Sent: 12 August 2026 12:17
To: DC Admin
Subject: Fwd: Planning Application: 2026/62/91763/E Objection

Planning Application: 2026/62/91763/E
Land off Barnsley Road, Denby Dale, Huddersfield, HD8
Proposal: Erection of 40 residential dwellings and associated works

SITE LAYOUT PLAN - 2530-SI-02F
BARNSLEY ROAD, DENBY DALE
NEWETT HOMES
SCALE:1:500@A1 - AUGUST 2025

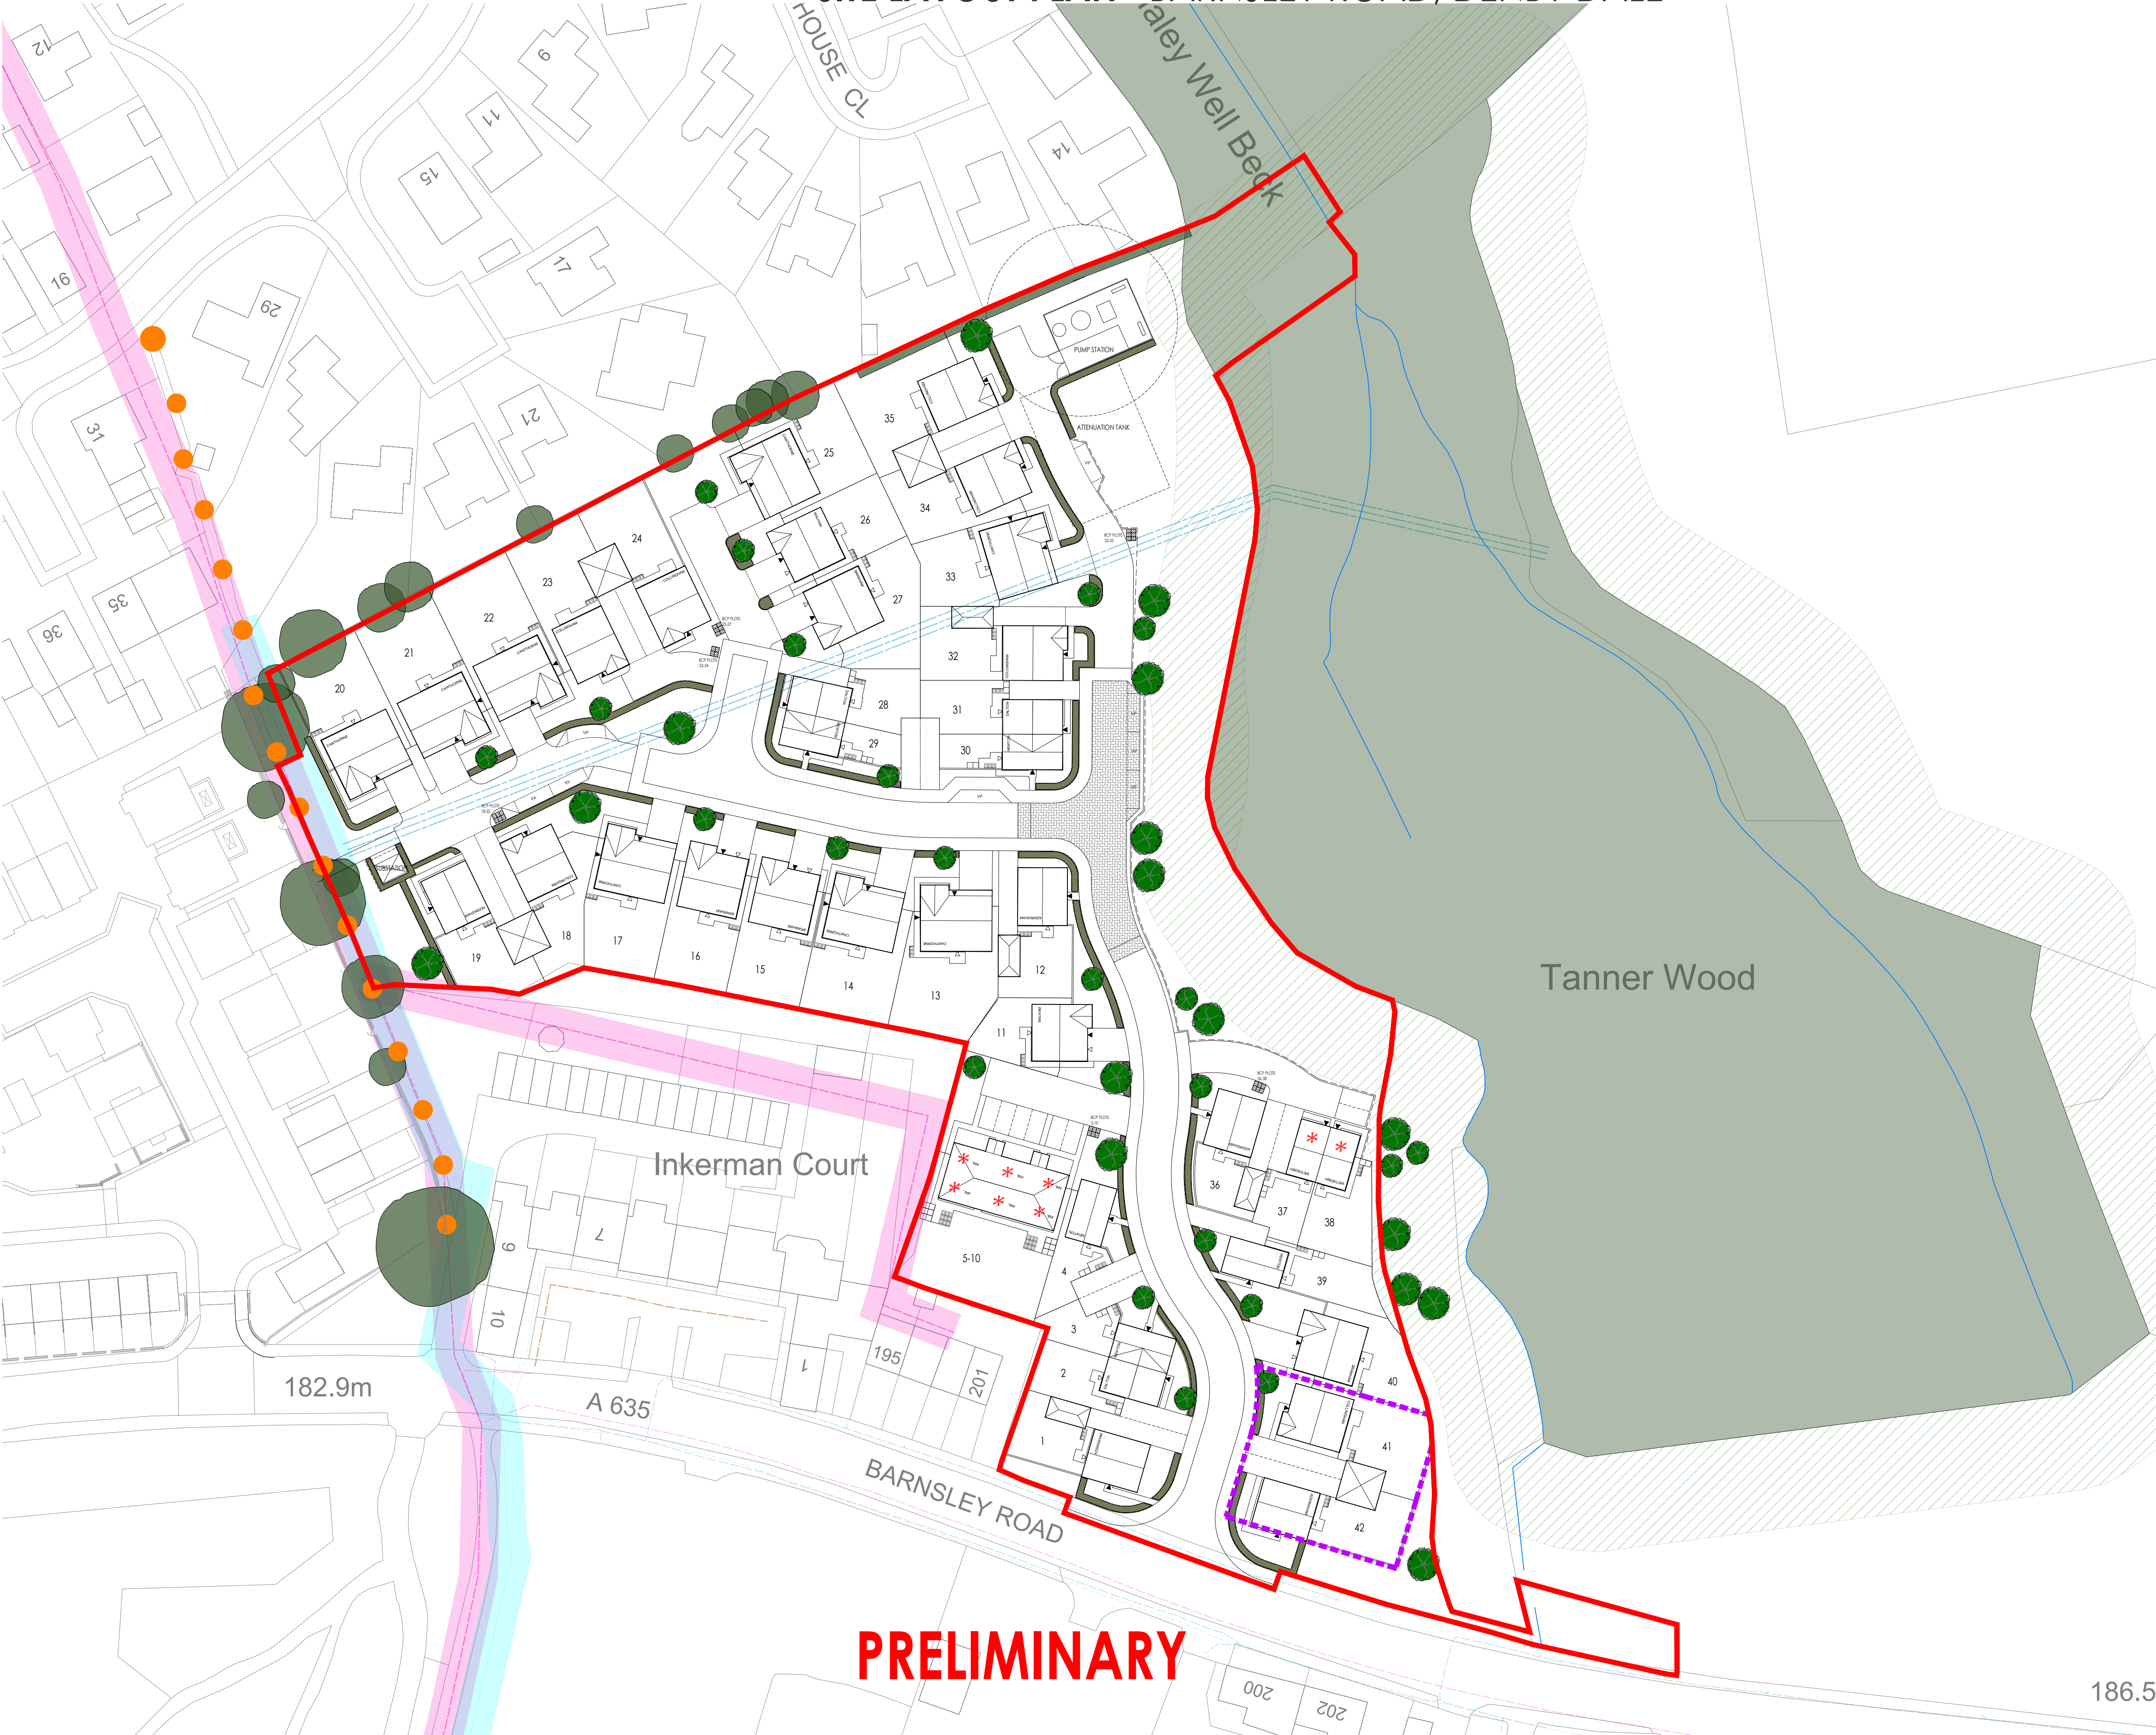
The applicant's current plans identify **40 separate plots**, numbered 1–40.

The application proposes **85 vehicle parking spaces for 40 dwellings**.

However, the proposed development contains **32 market houses**, of which 23 are four-bedroom or larger. There are also four affordable three-bedroom houses and four one-bedroom flats.

SEPARATION DISTANCE PLAN - BARNSLEY ROAD, DENBY DALE

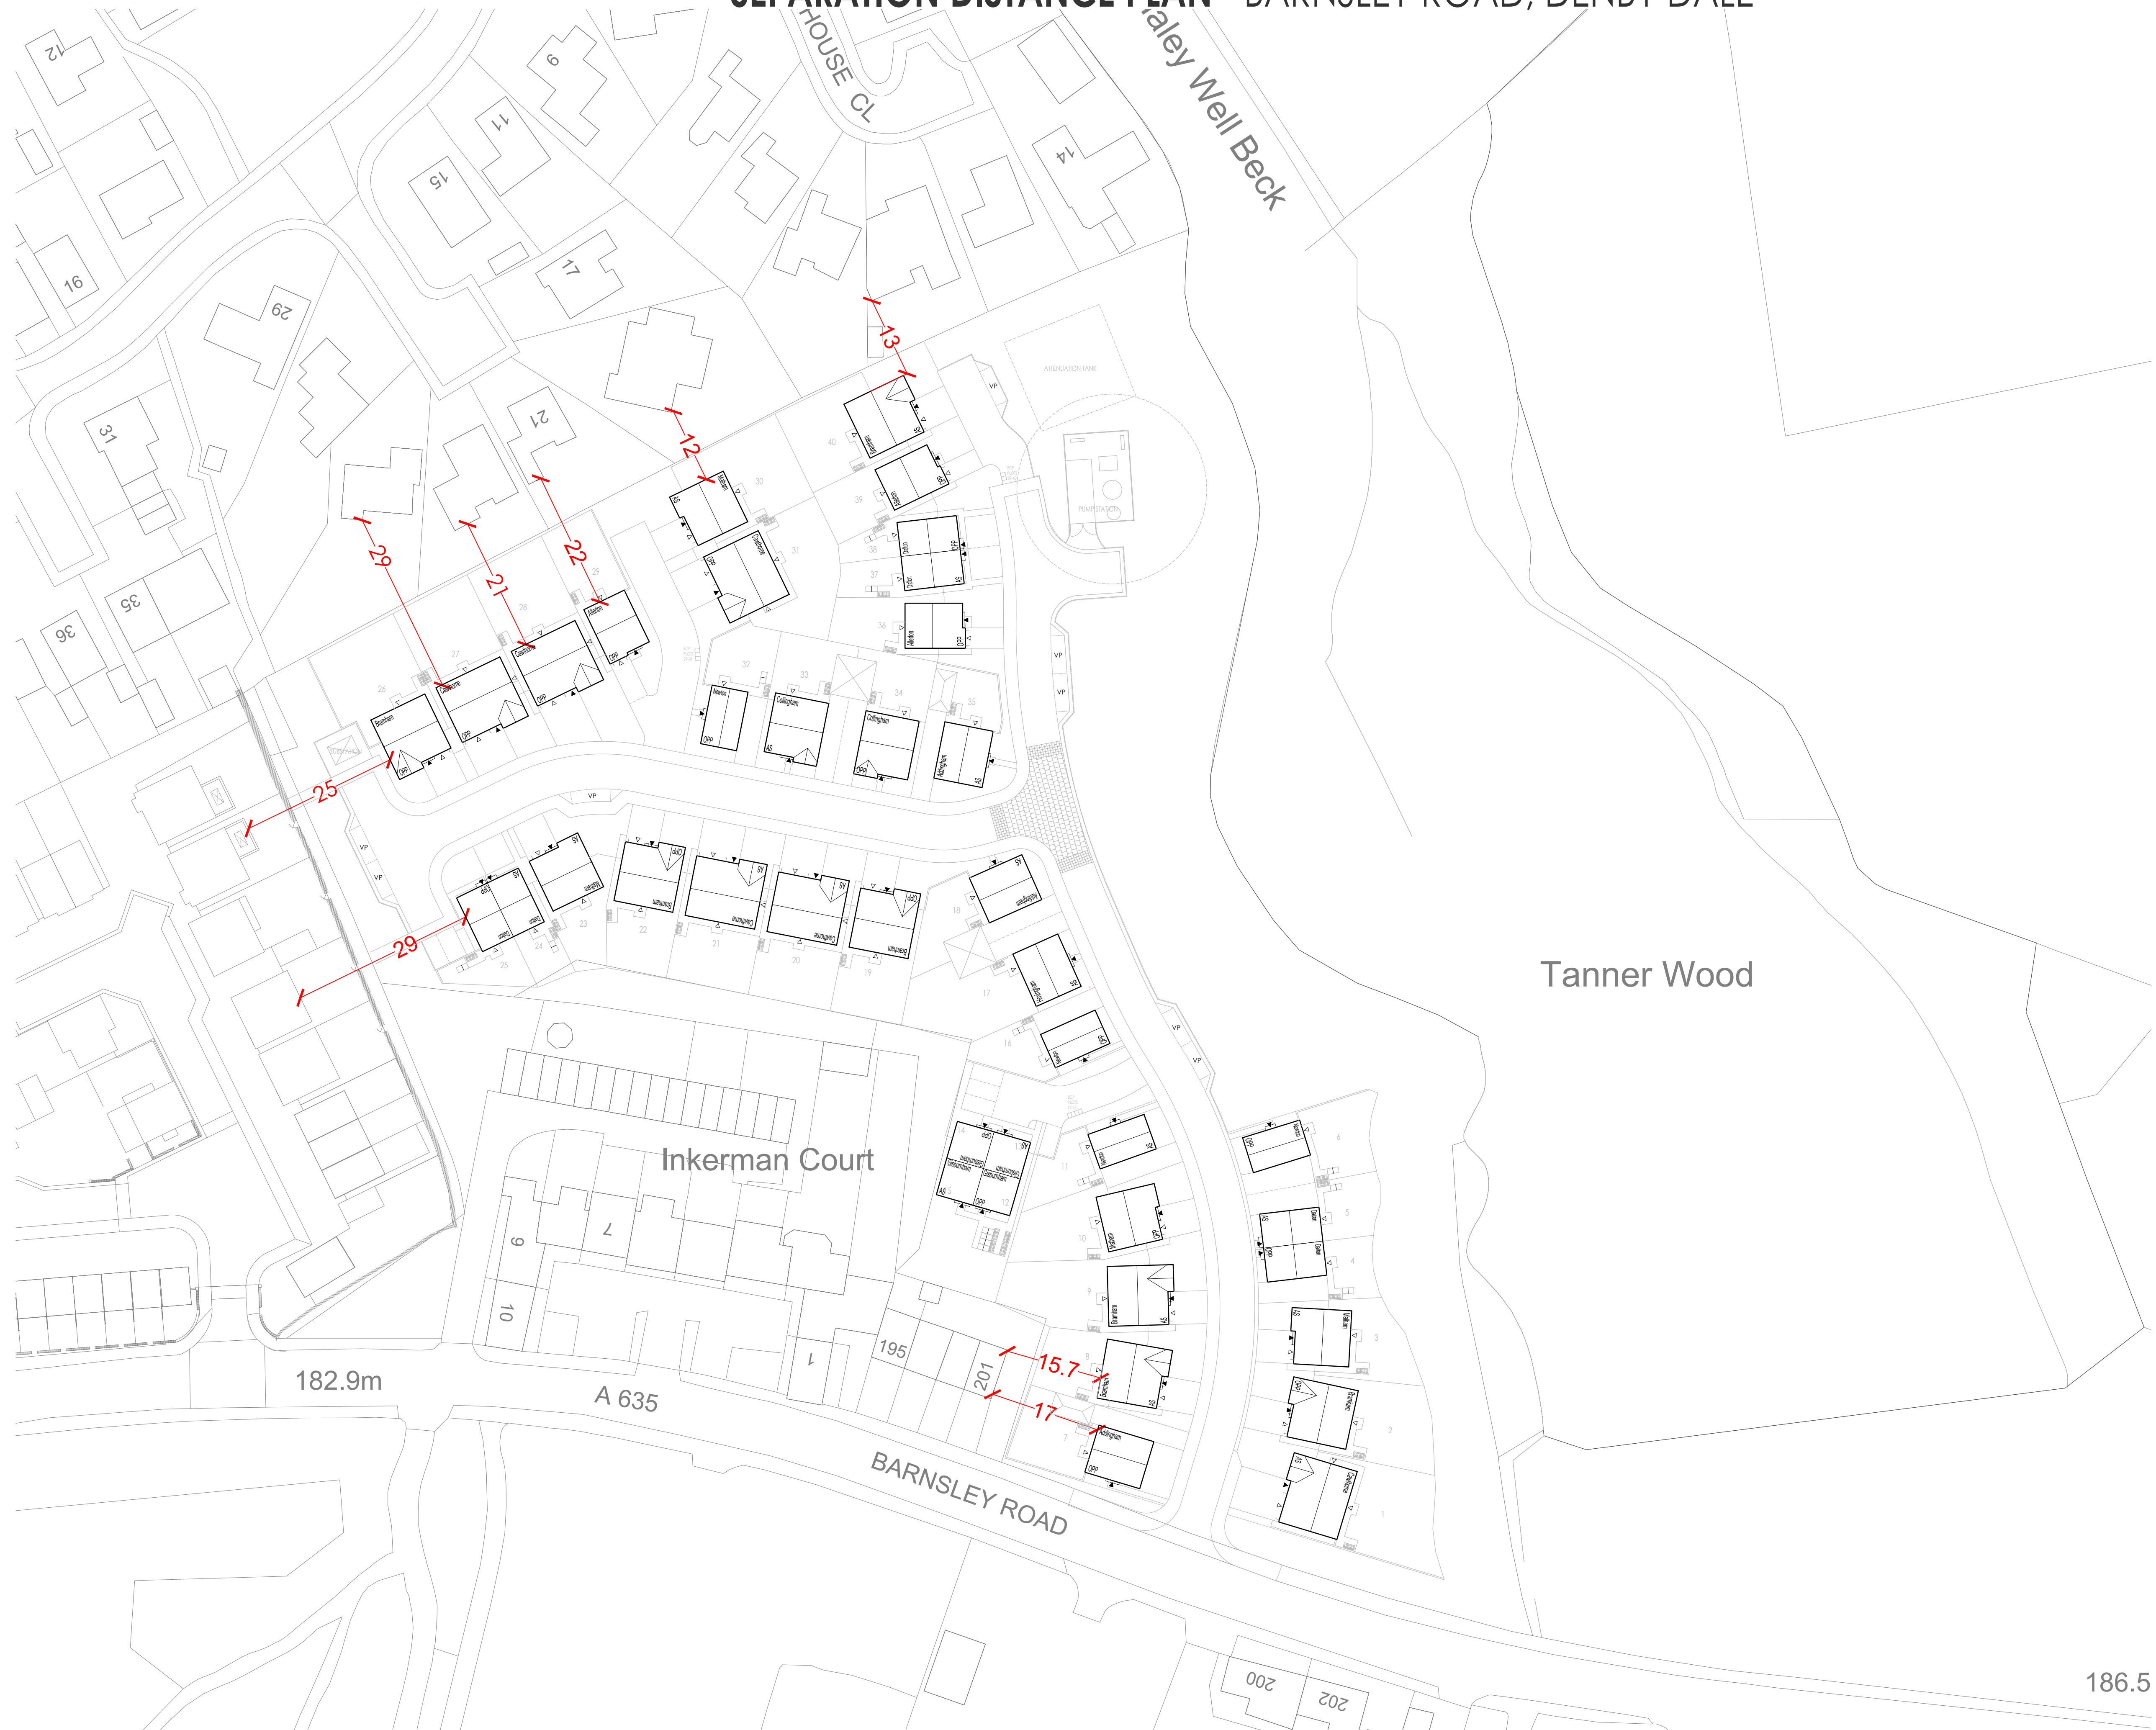
The separation-distance evidence deserves particular scrutiny

The Council should therefore carefully compare the current layout against the approved 30-dwelling layout and establish whether the additional density has created a more intensive relationship with existing residents.

I particularly ask the Council to undertake that comparison
